Comments for Planning Application 19/03203/CONDIT

Application Number: 19/03203/CONDIT

Address: 69 - 71 Church Road Anerley London Bromley SE19 2TA

Proposal: Details submitted to discharge condition in relation to planning ref:

Title  
PROPOSED ELEVATIONS  
SHOWING LIGHTING AND FLOOR LEVELS  
& PROPOSED MATERIAL FINISHES

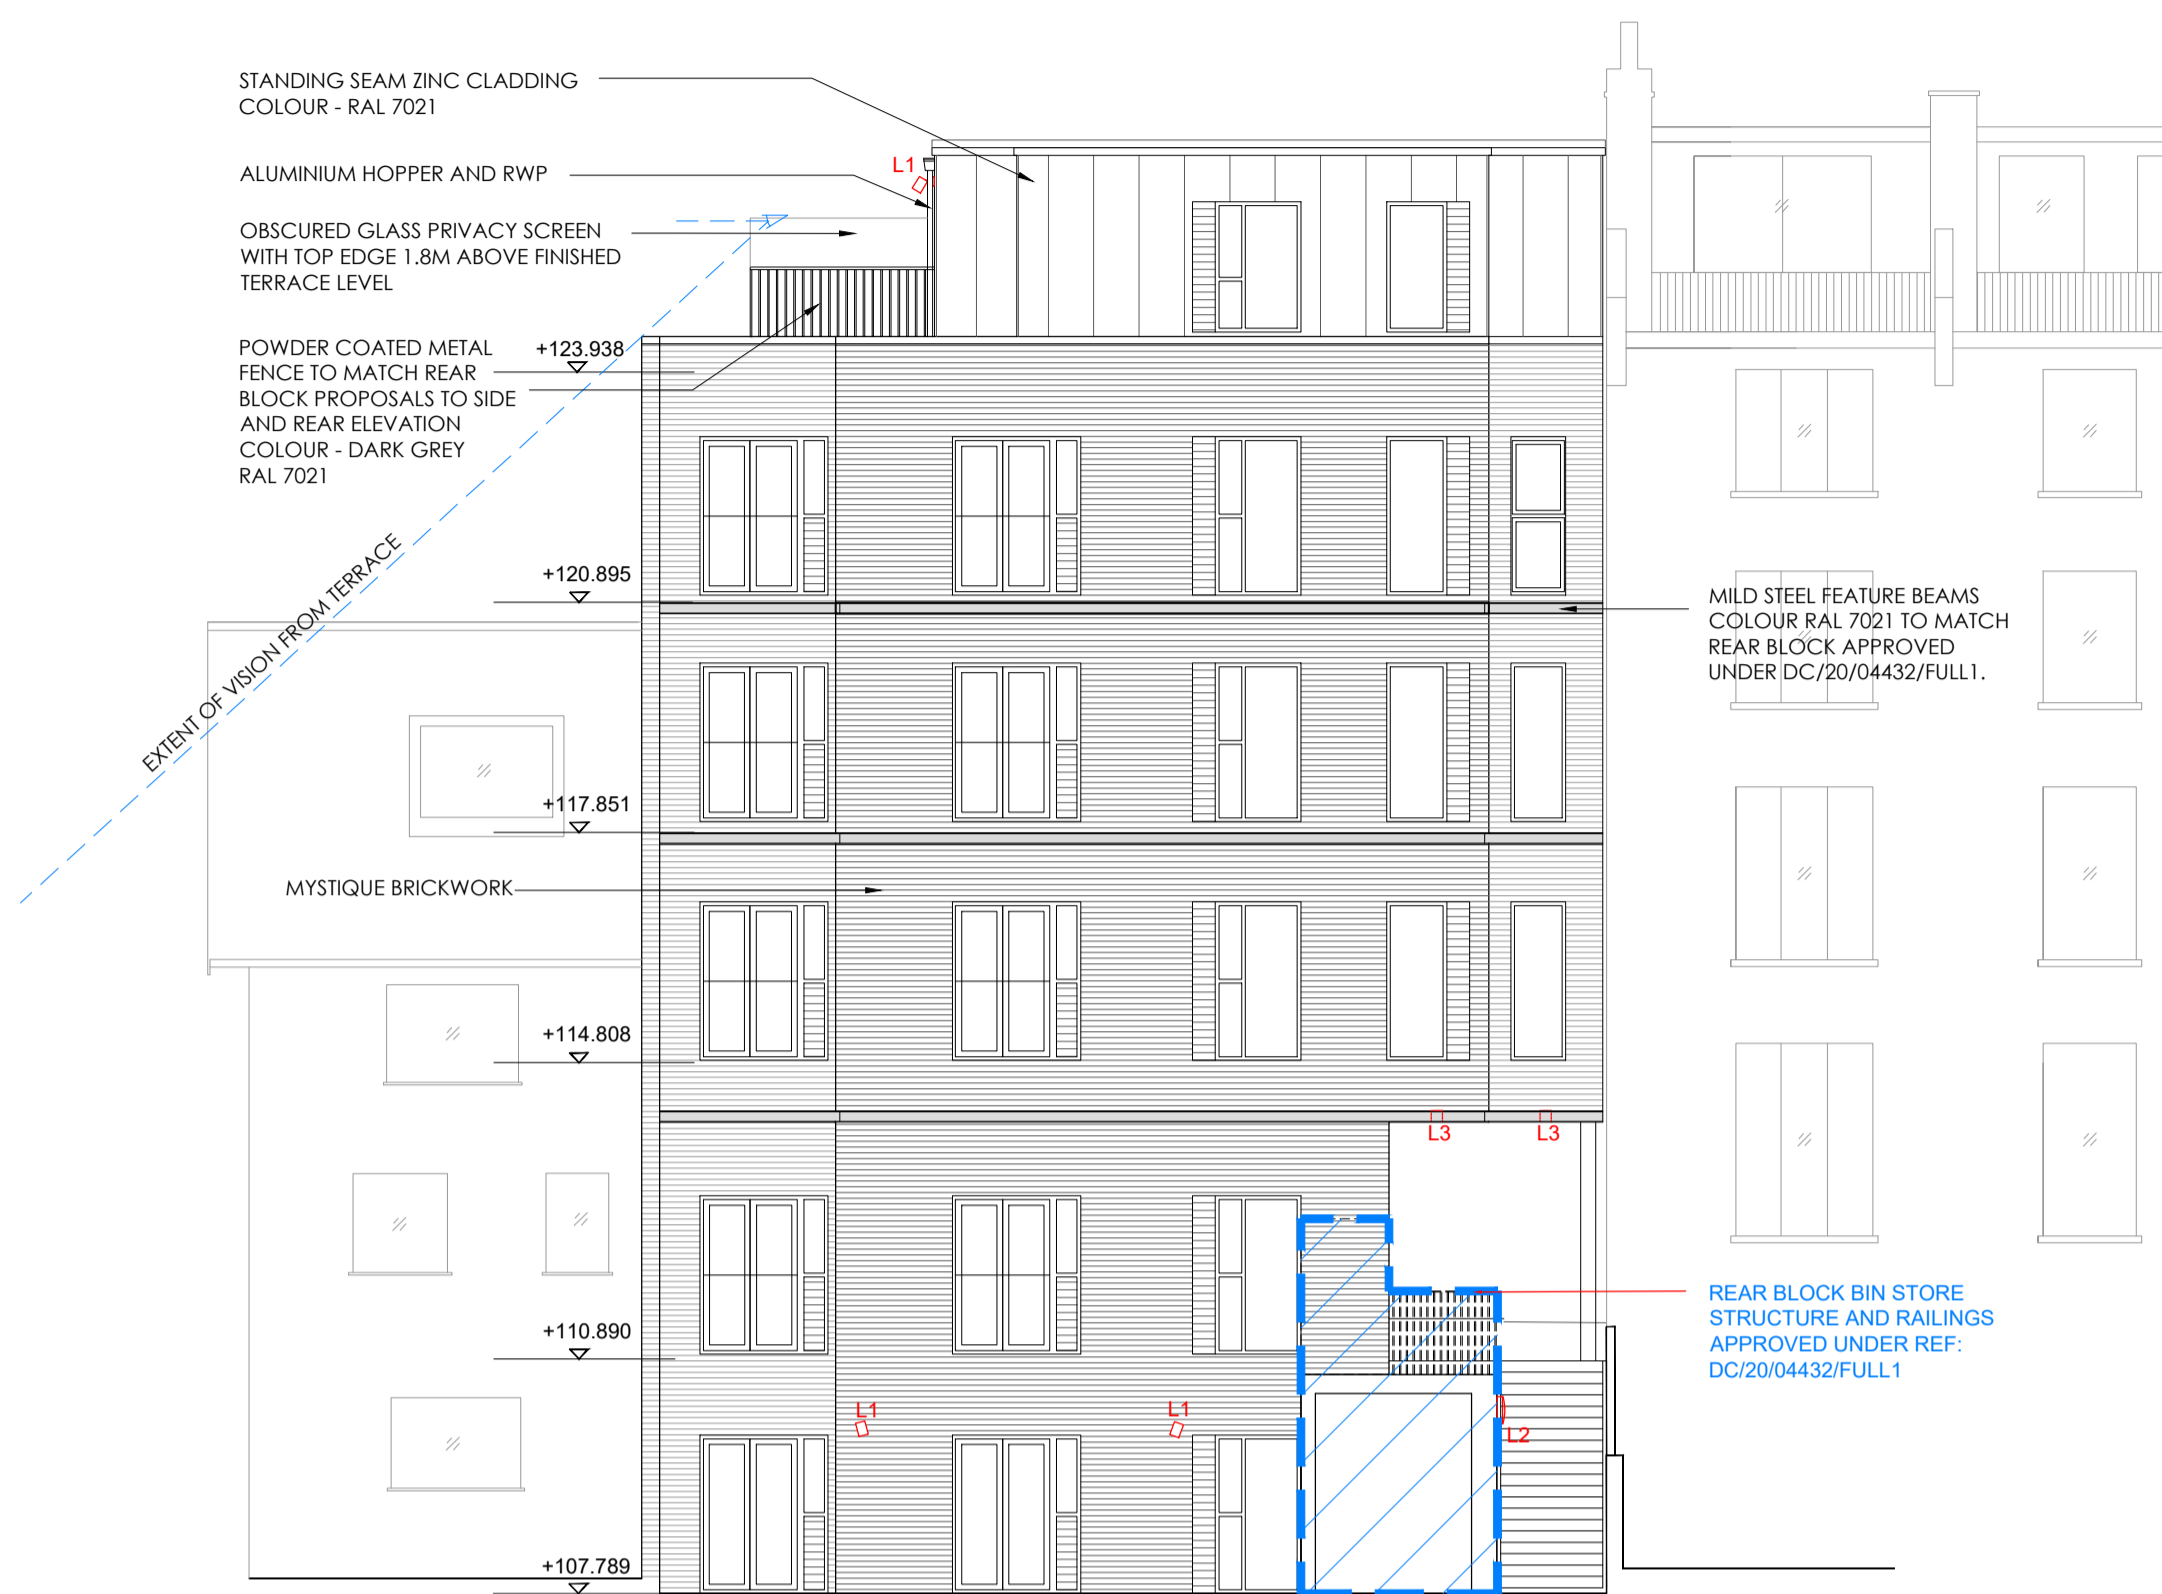
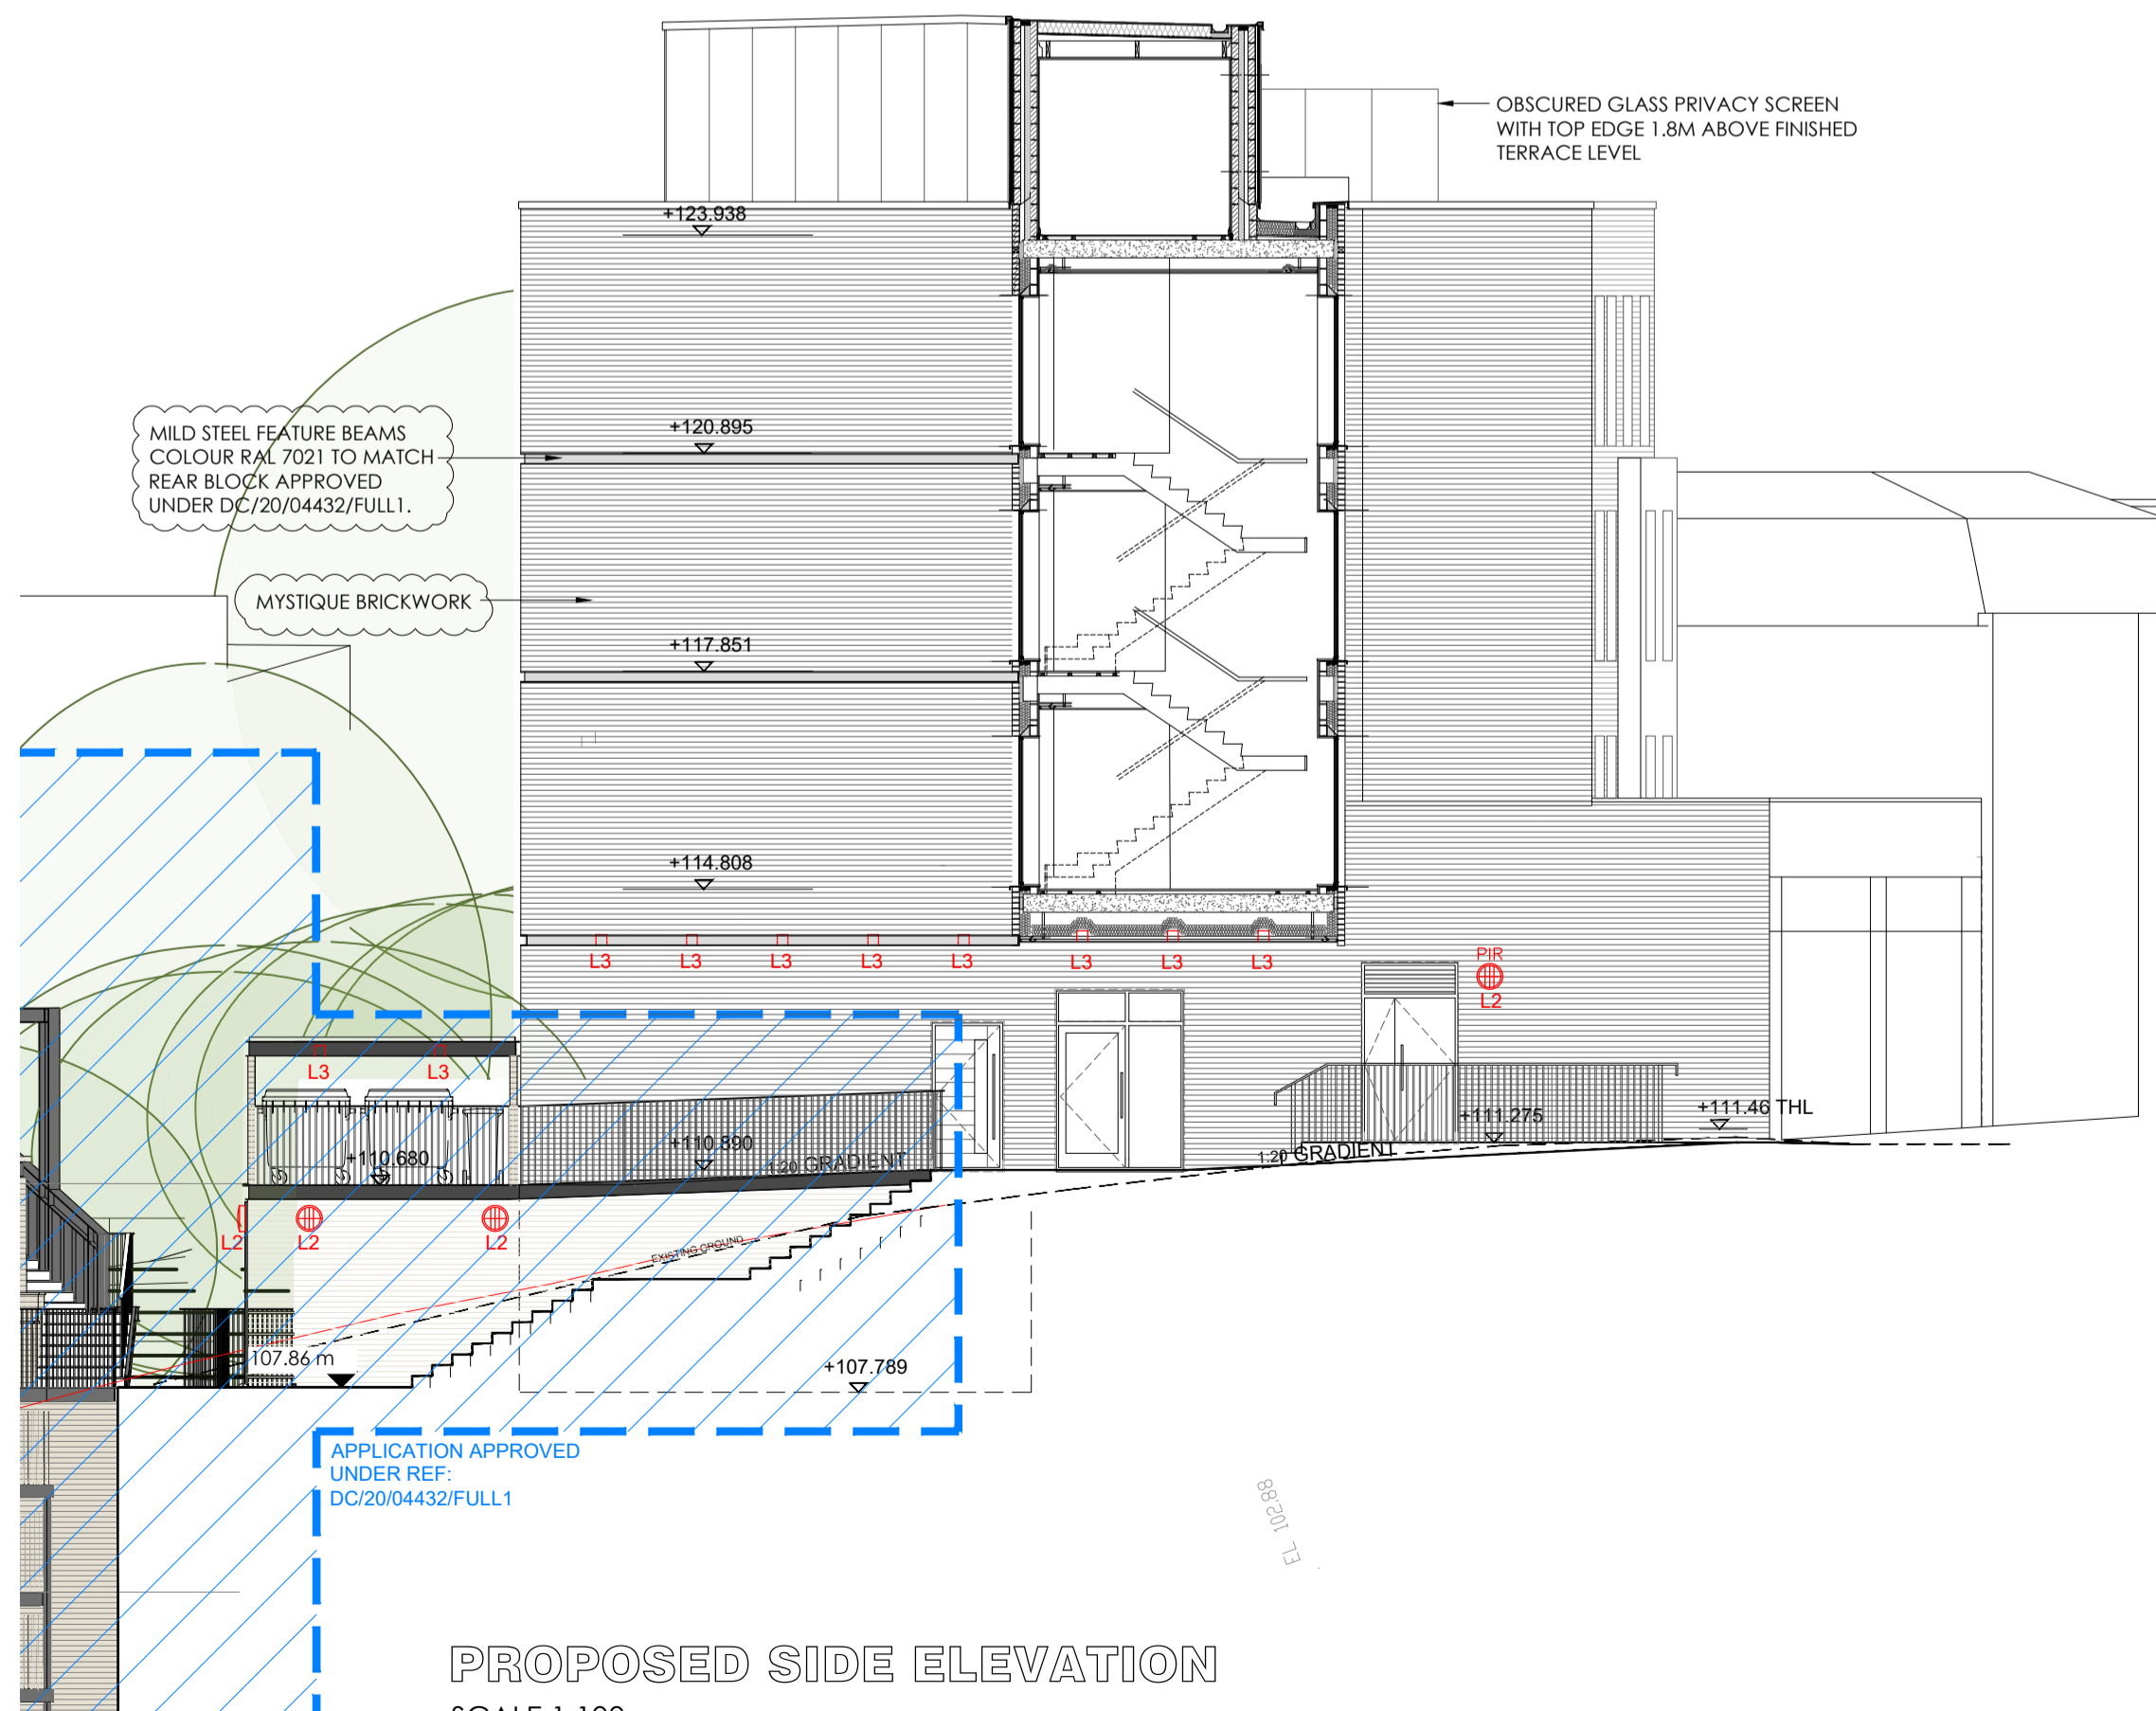
Comment: The roof top arrangements allows people to state into my daughter bedroom and my bathroom at 60 c church Rd. The the privacy screen should be raised to 2m above floor level. This will also protect the privacy of other adjacent neighbours.
